Our ref: OUT10/15811

Your ref: MP10_0060

**Exhibition of Environmental Assessment for the Redevelopment of Sydney Fish Markets
(MP10_0060)**

Thank you for your letter dated 20 September 2010 requesting Industry & Investment NSW (I&I NSW) comment on the environmental assessment (EA) for the proposed redevelopment of the Sydney Fish Markets.

--- Existing seawalls

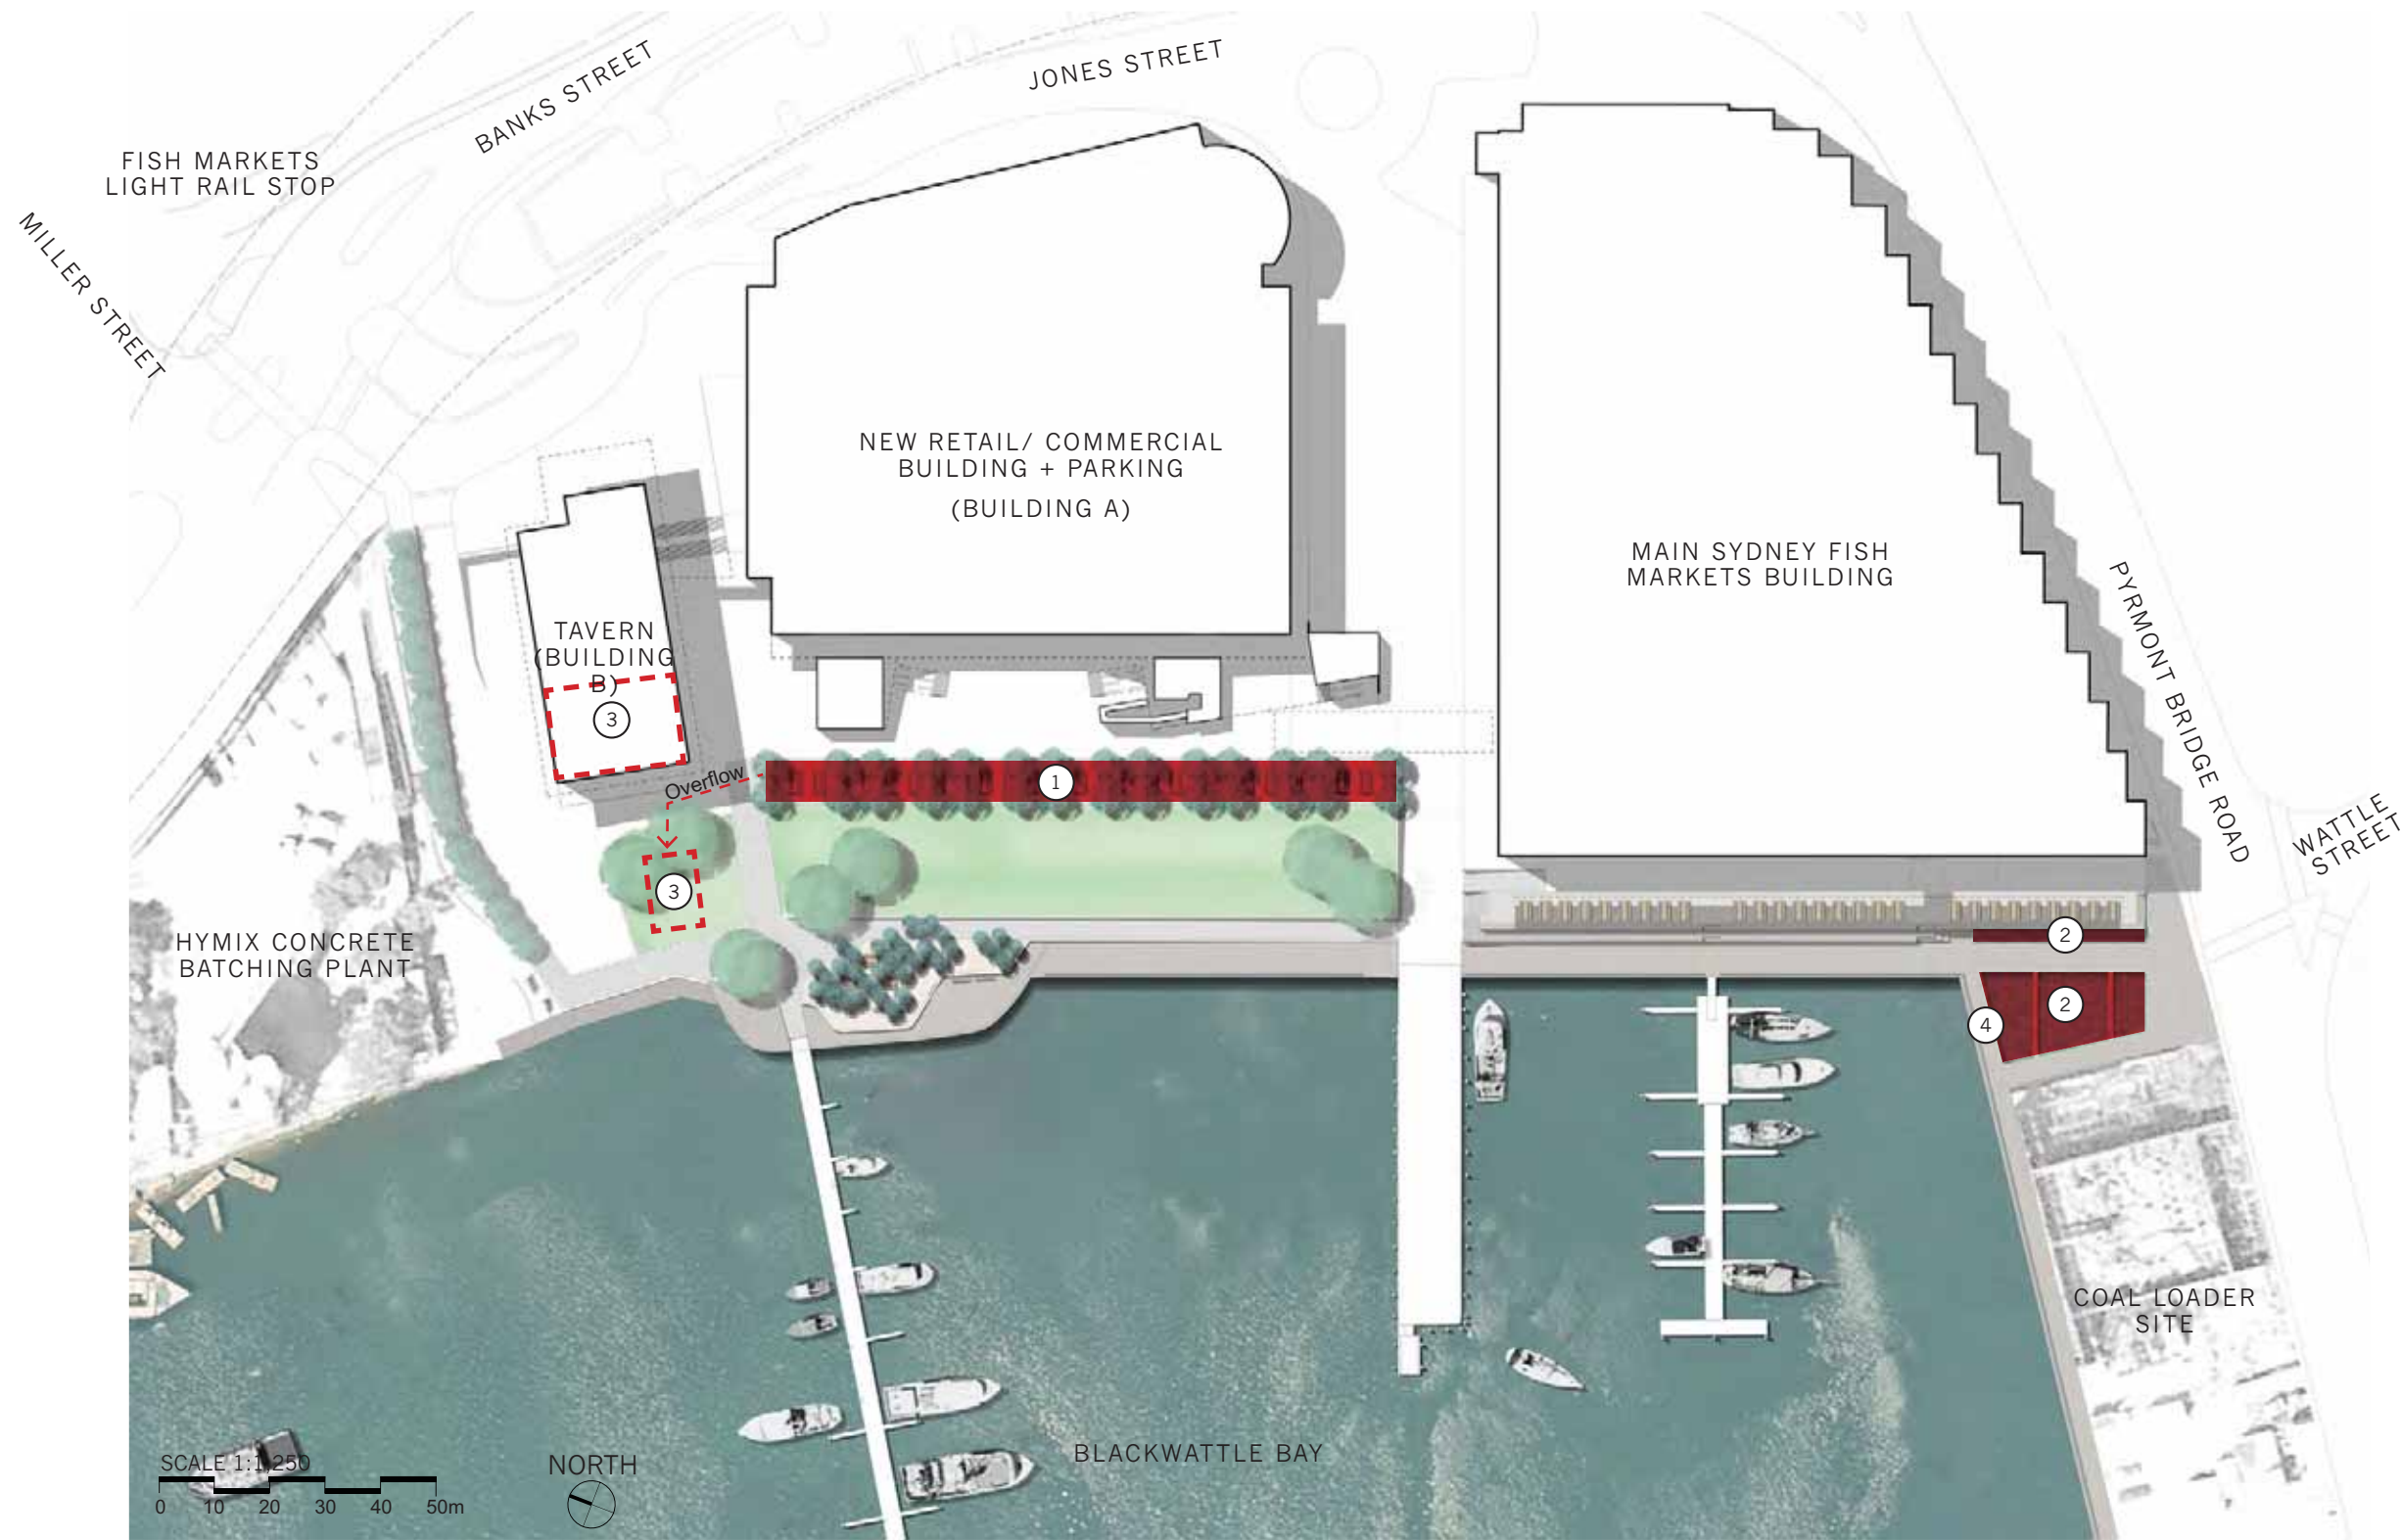
I&I NSW recommends that in-lieu of the vertical and steel sheet piling seawalls proposed for part of the reconstructed seawall that sloping seawalls of an environmentally-friendly design are used. These seawalls will provide greater habitat value for aquatic organisms and minimise refraction-related erosion. For further information about environmentally-friendly seawall designs see: http://sydney.cma.nsw.gov.au/index.php?option=com_remository&Itemid=116&func=startdown&id=315
